**New Request for Advice – Sydney Business Park – Stage 3  
(SSD-10477) (Blacktown)**

## TAB A - TfNSW comments on SSD-10477 Sydney Business Park, Stage 3 EIS

Drawing Title
WH1 - SITE PLAN

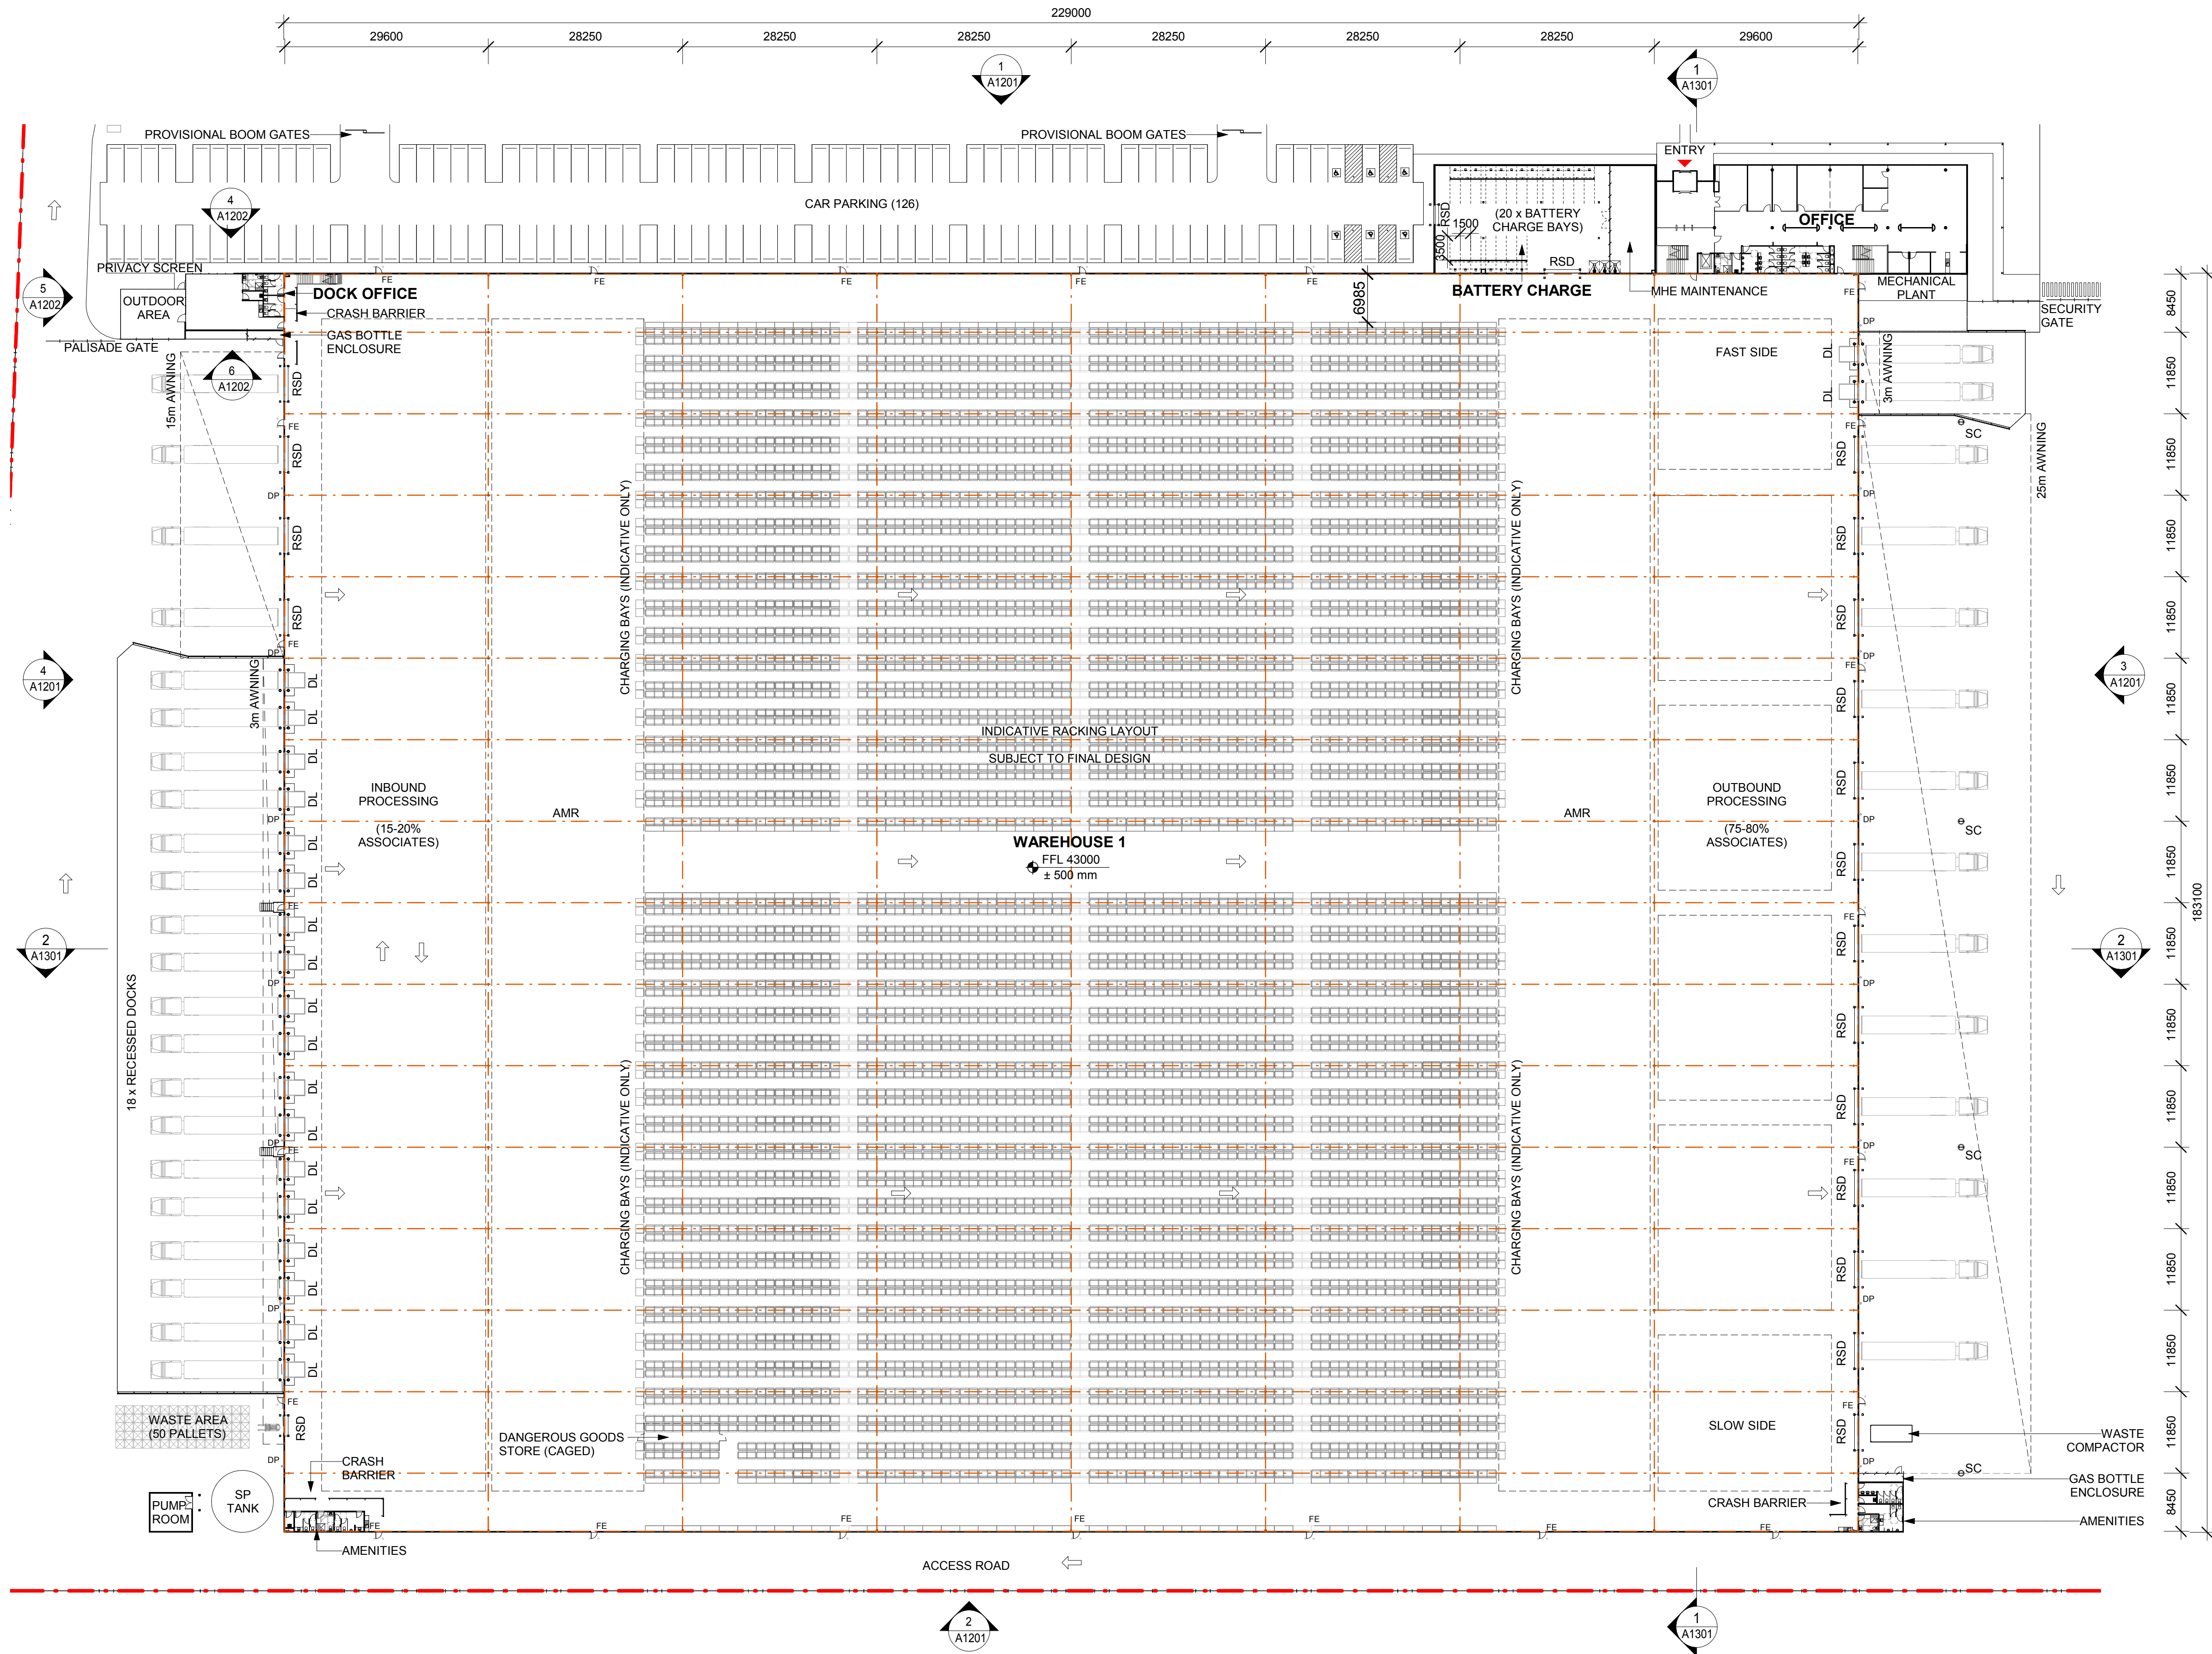
The TA demonstrates that there is minimal storage for heavy vehicles queuing at security gates with 30m of queuing space provided at warehouse 1 and 35m of queuing space at warehouse 2. Considering warehouses 1 and 2 have been designed to accommodate vehicles 30m and 25m in length respectively, the short queuing space means that one heavy vehicle waiting at the security gates may result in any additional heavy vehicles waiting to enter the site would need to queue onto the road network.

It is requested the proponent provides further details demonstrating how warehouses 1 and 2 will prevent and/ or mitigate queuing of heavy vehicles on the public road network.

Drawing Title
WH3 - SITE PLAN

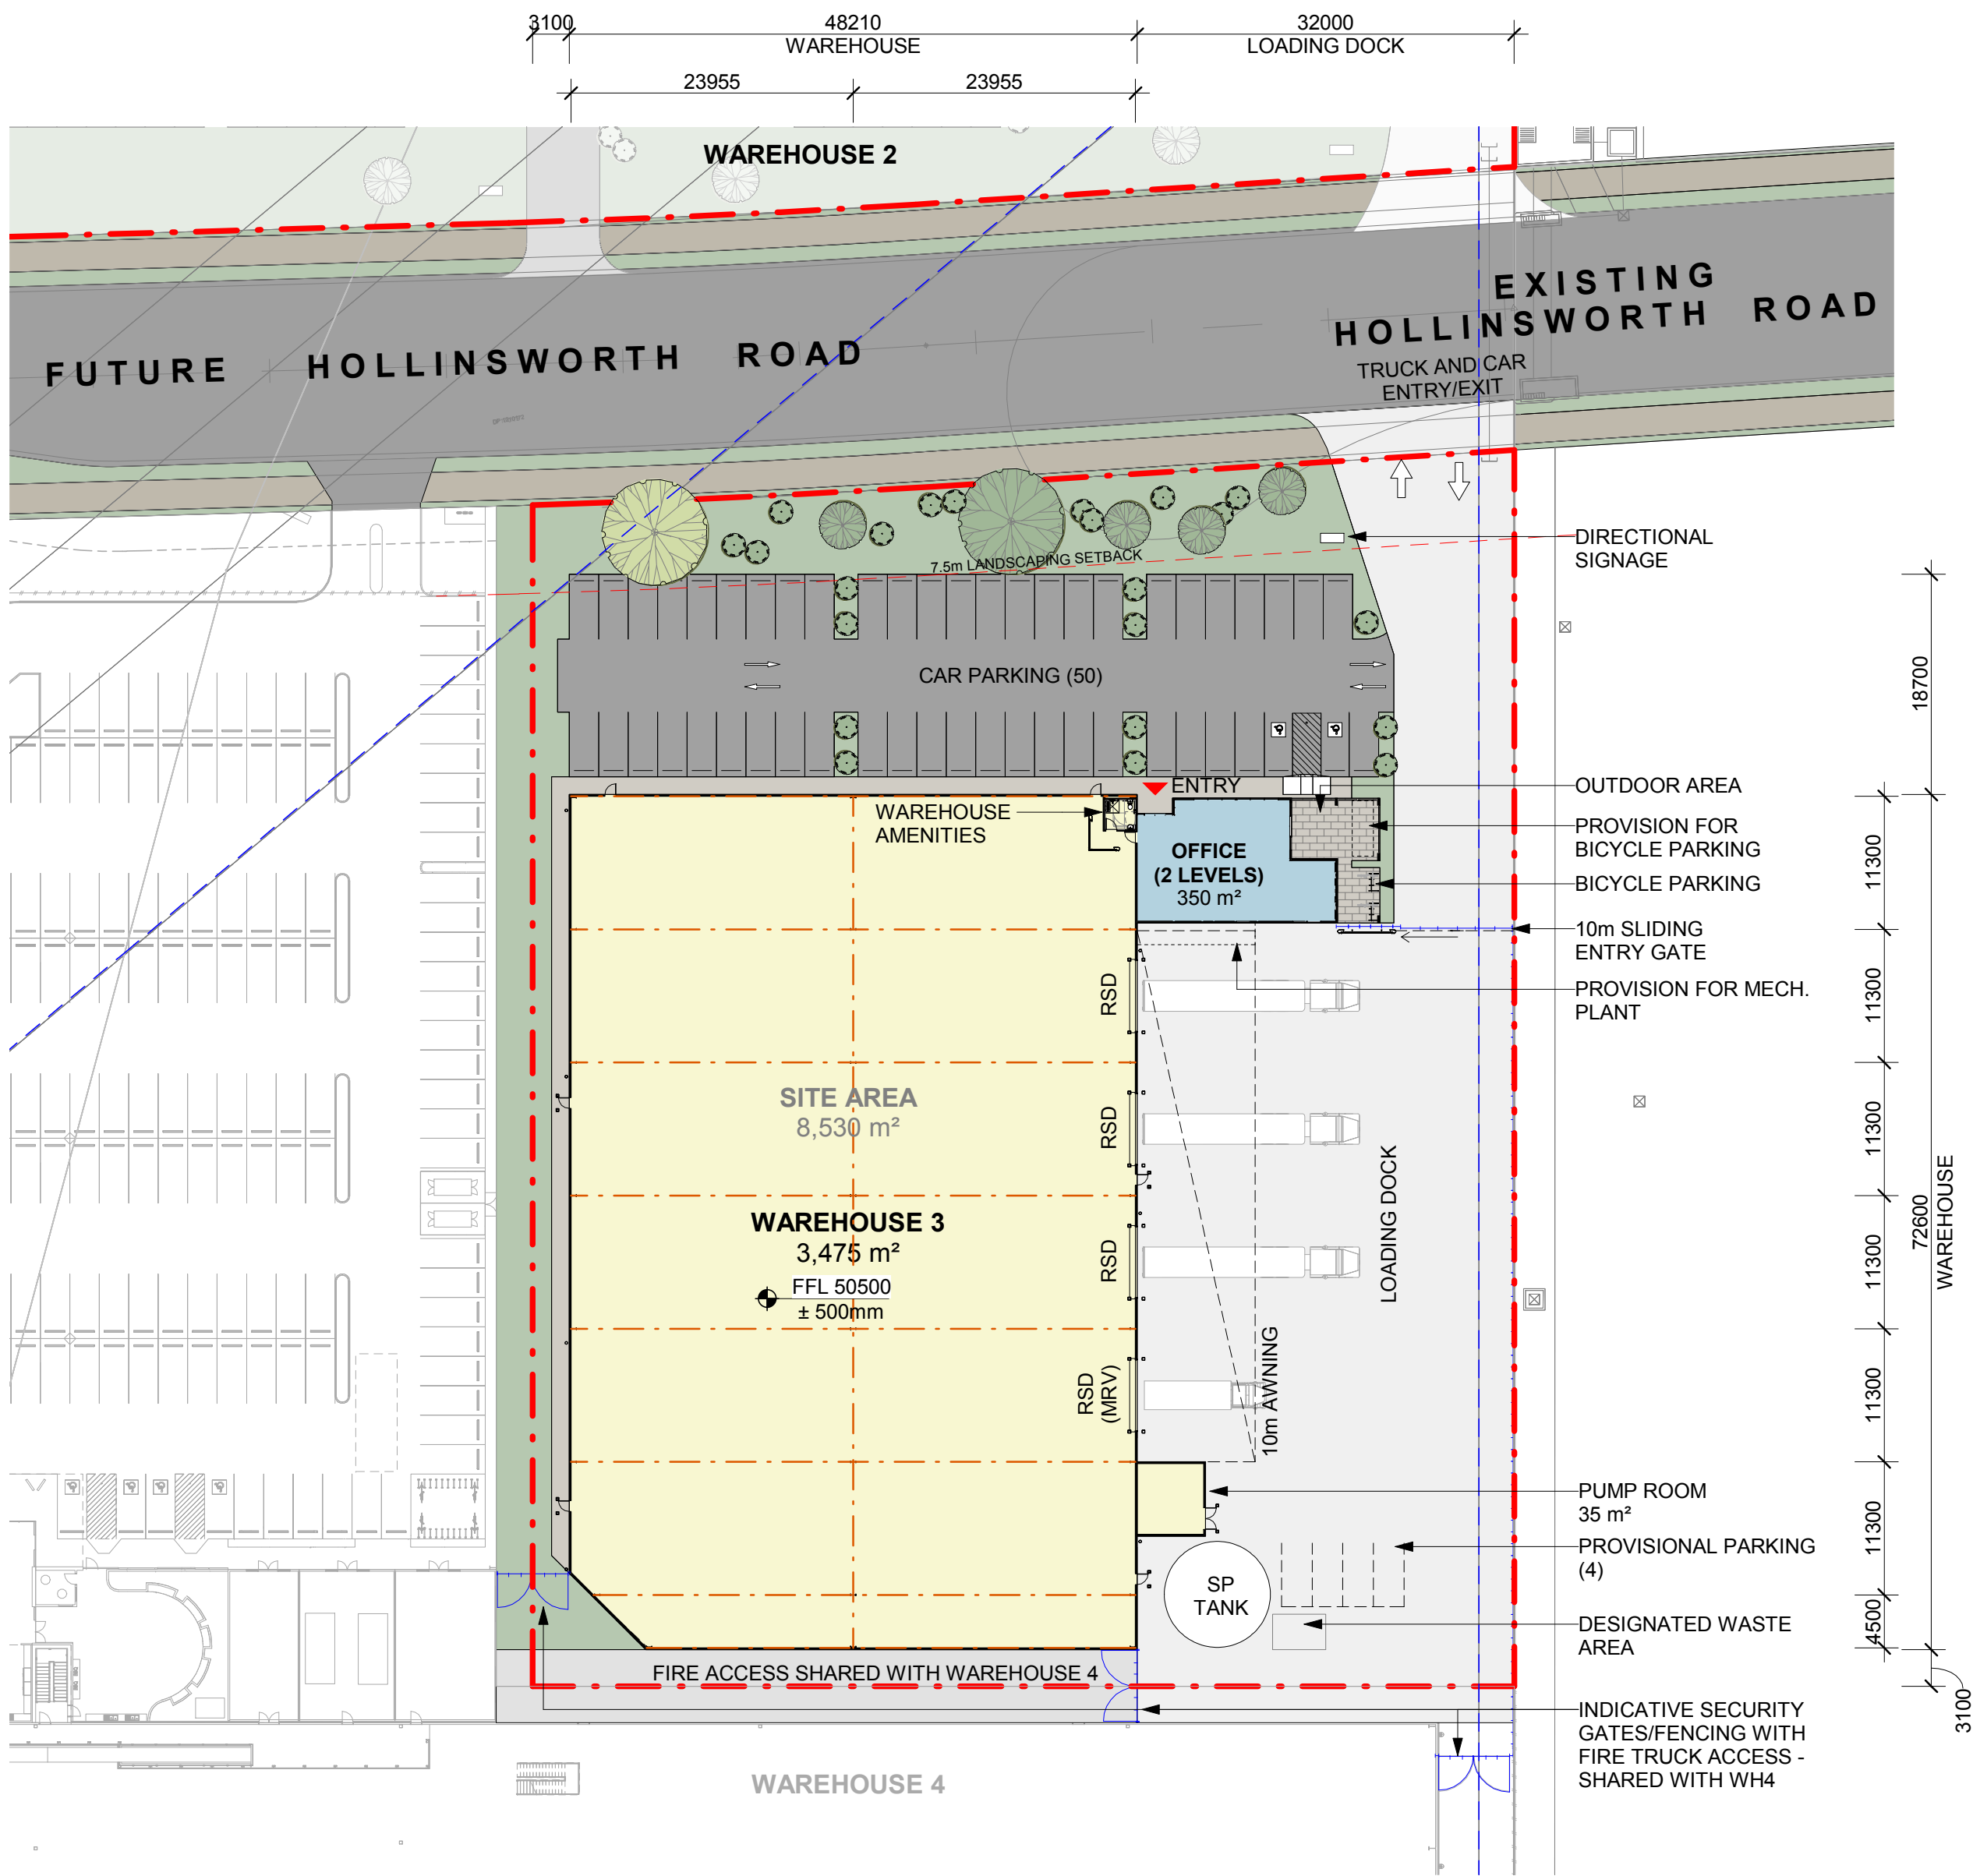
It is not clear why the TA combines light and heavy vehicle accesses to warehouse 3 as this may introduce conflicts between heavy vehicles and other on-site activities (pedestrian movements, light vehicles).

It is requested the proponent provide justification for having a combined light and heavy vehicle access to warehouse 3.
